13 February, 2013

M&L Development Co Pty Limited
Suite 2.02B, Level 2
350 George Street
SYDNEY NSW 2000

**RE: PART 3A PROJECT: PROPOSED ADDITIONS TO
FOUR POINTS HOTEL, SUSSEX STREET, SYDNEY**

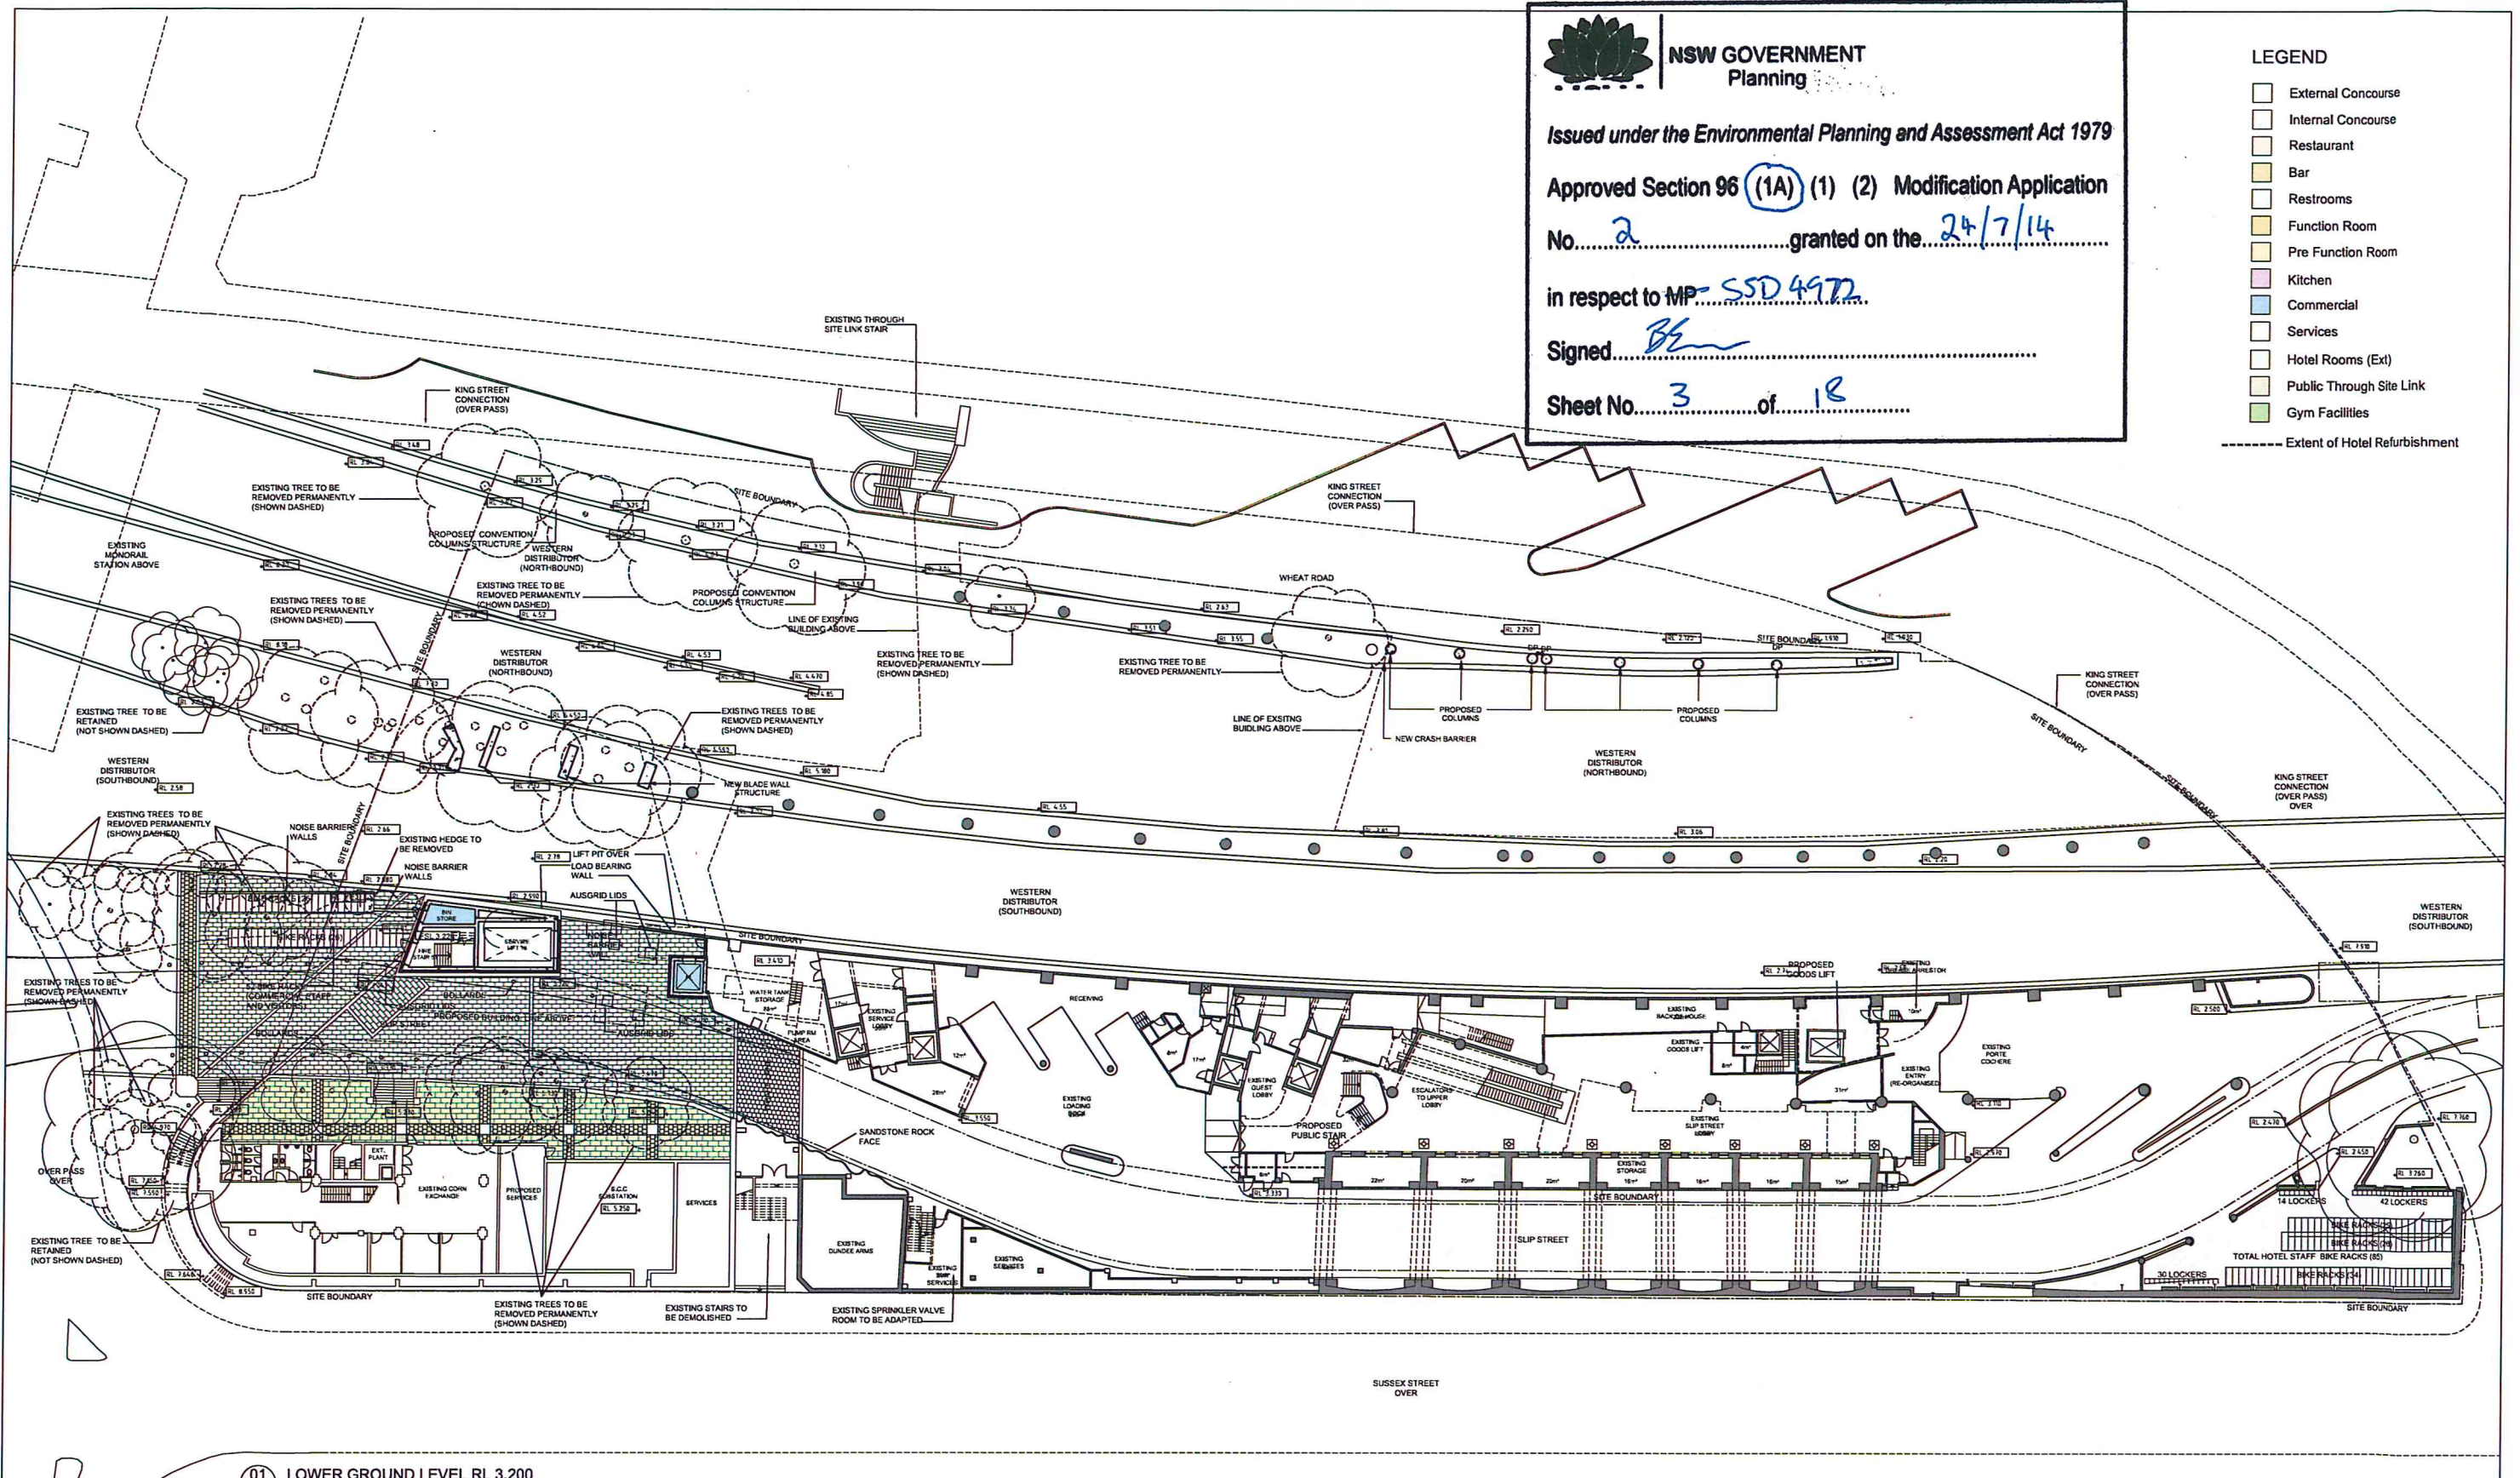
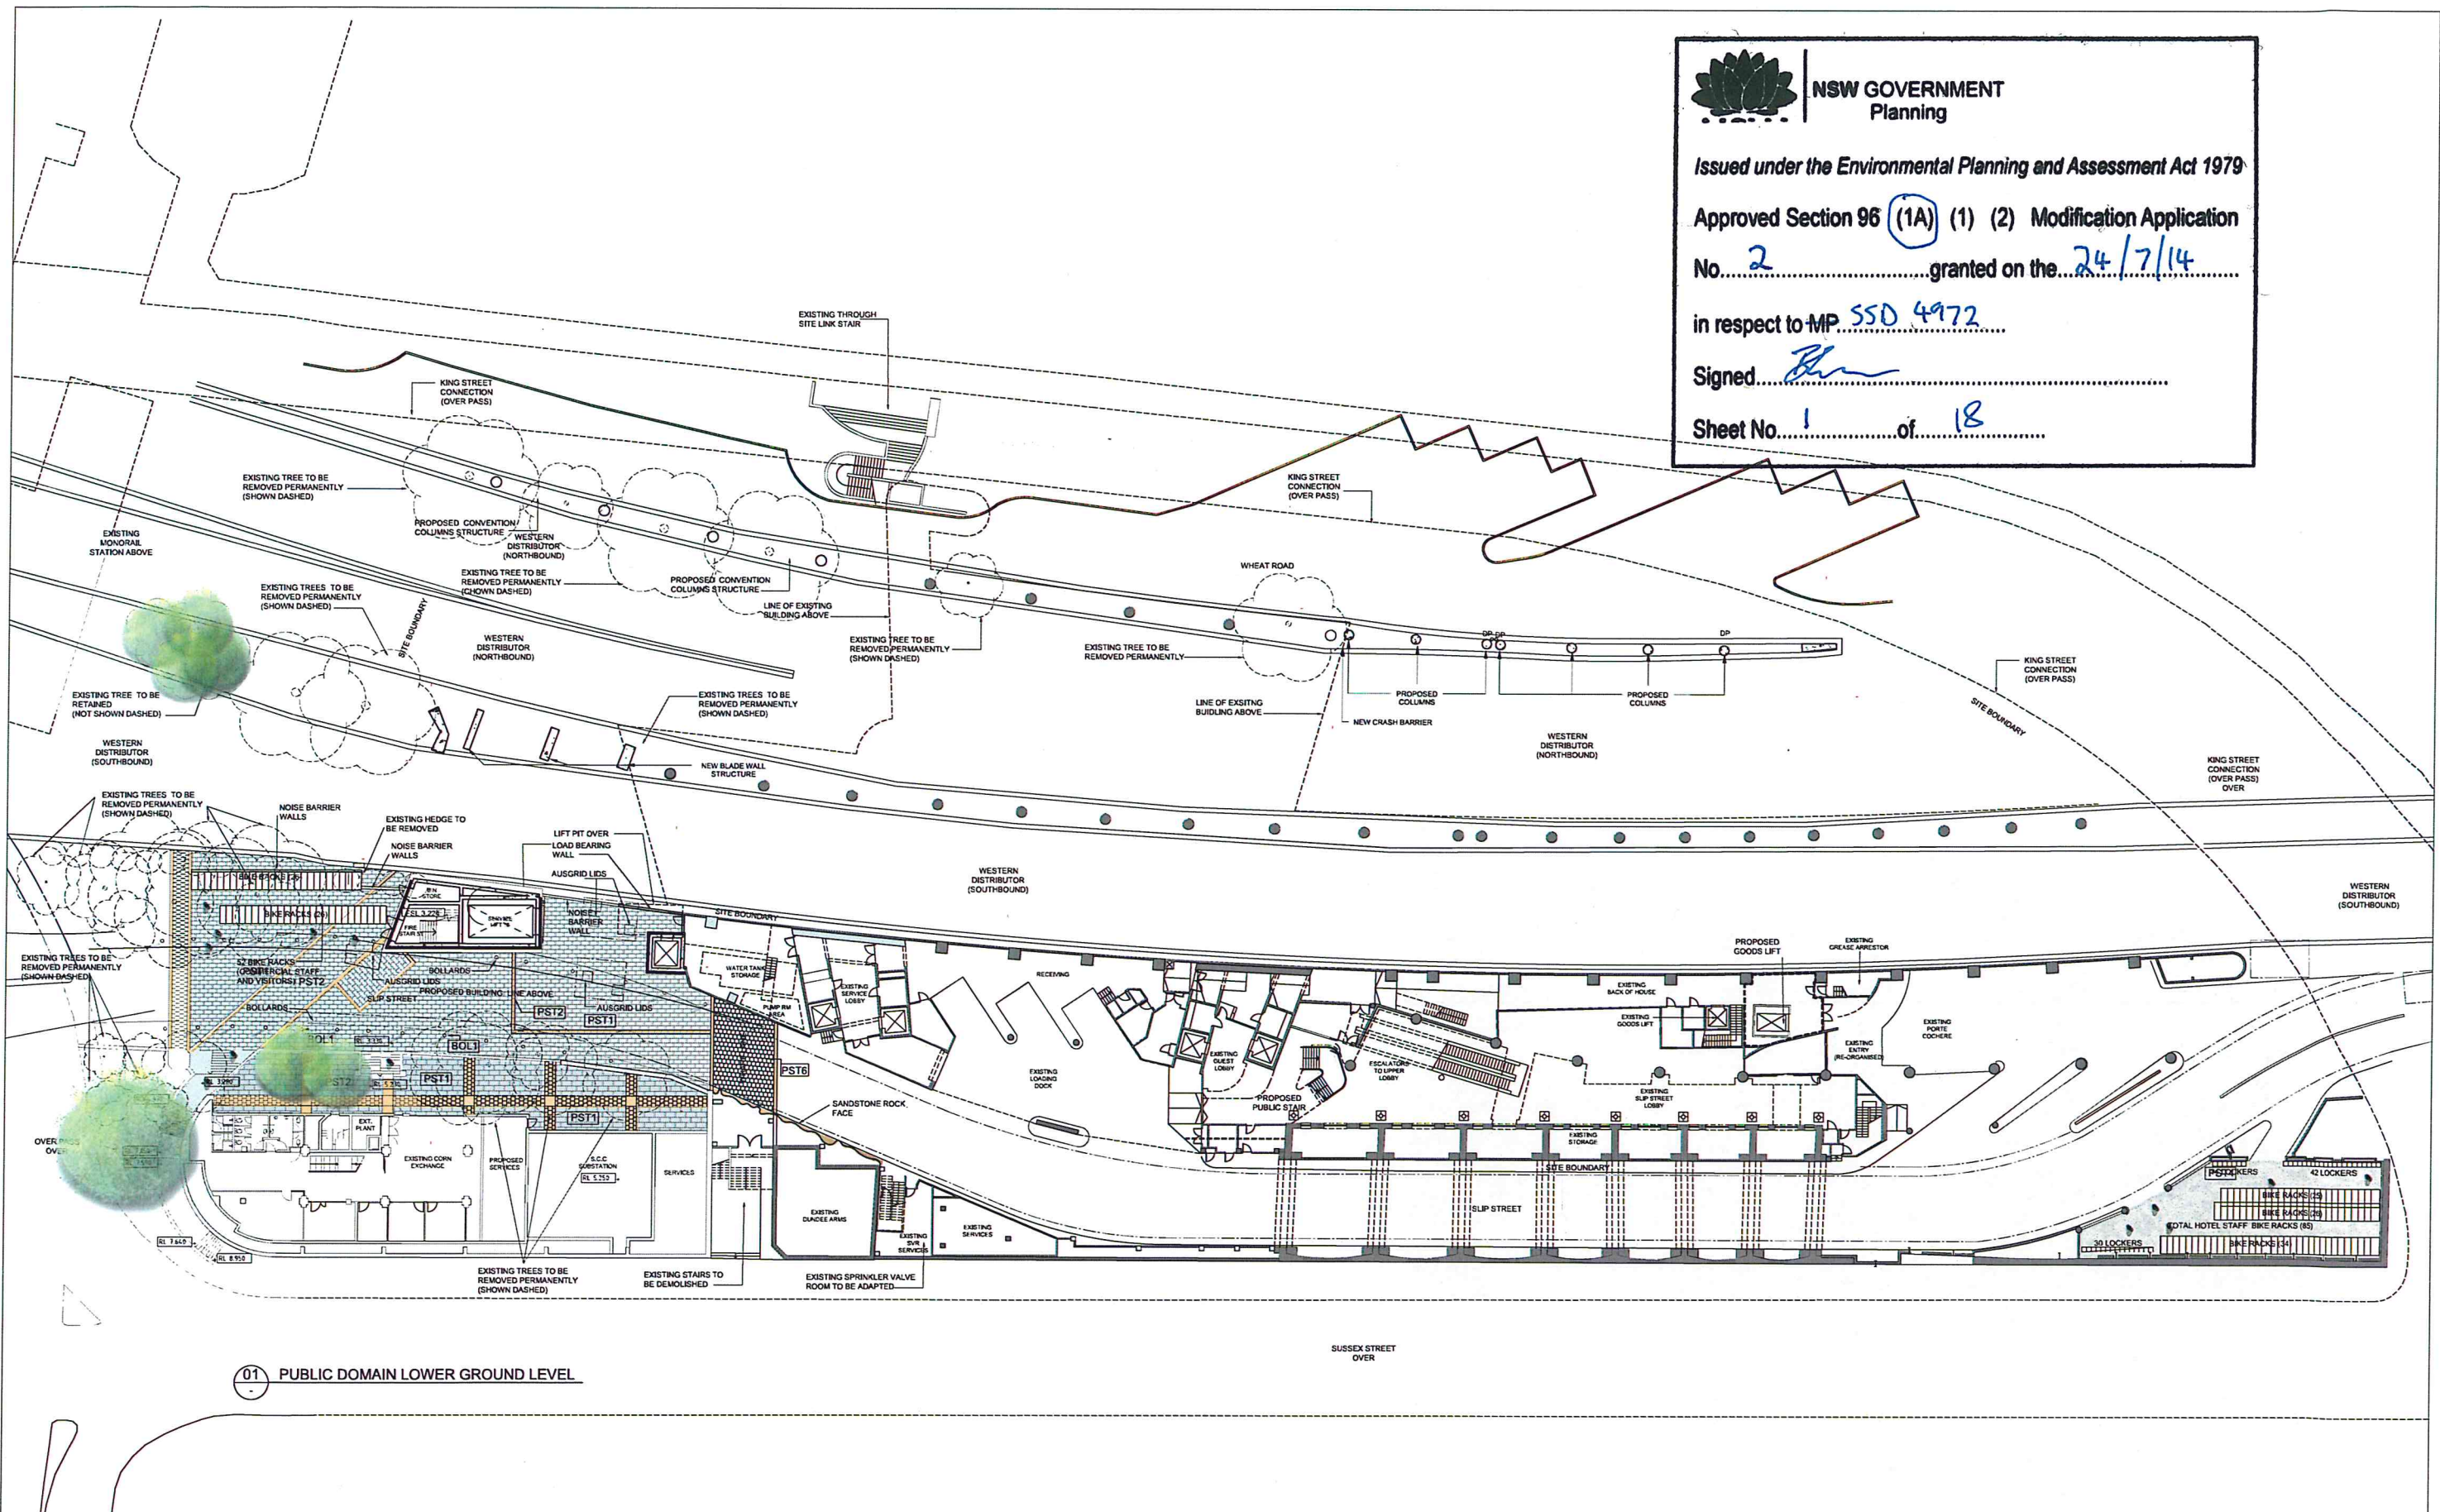
Provide more information about how the porte cochere on Sussex Street is intended to operate. Detail any design elements proposed to manage potential vehicle and pedestrian conflicts to ensure that the area functions safely.

3. Access to the porte cochere will be provided via separate entry and exit driveways onto Sussex Street. The porte cochere will be extended, as shown on plans prepared by Cox Architects, to provide added capacity for the set-down and pick-up of hotel guests/conference delegates. However, the extent to which the porte cochere can be extended is restricted by the existing heritage buildings located either side of the facility.

4. As shown on Figure 1, the entry and exit driveways and the internal circulation within the porte cochere has been designed to cater for cars, taxis and hire cars, with appropriate sight lines for entering and exiting traffic. The entry and exit driveways will be widened to 7 metres to cater for the swept path of vehicles and to provide a kerbside parking lane for the set-down and pick-up of guests and an internal circulation lane for vehicles to pass through the porte cochere.

6. The porte cochere will be managed and controlled by hotel personnel. These staff will assist guests/delegates in and out of waiting vehicles from the kerbside lane of the porte cochere, assist with the transfer of luggage, manage the movement of vehicles through the facility and ensure that vehicles do not park for extended periods within the porte cochere.
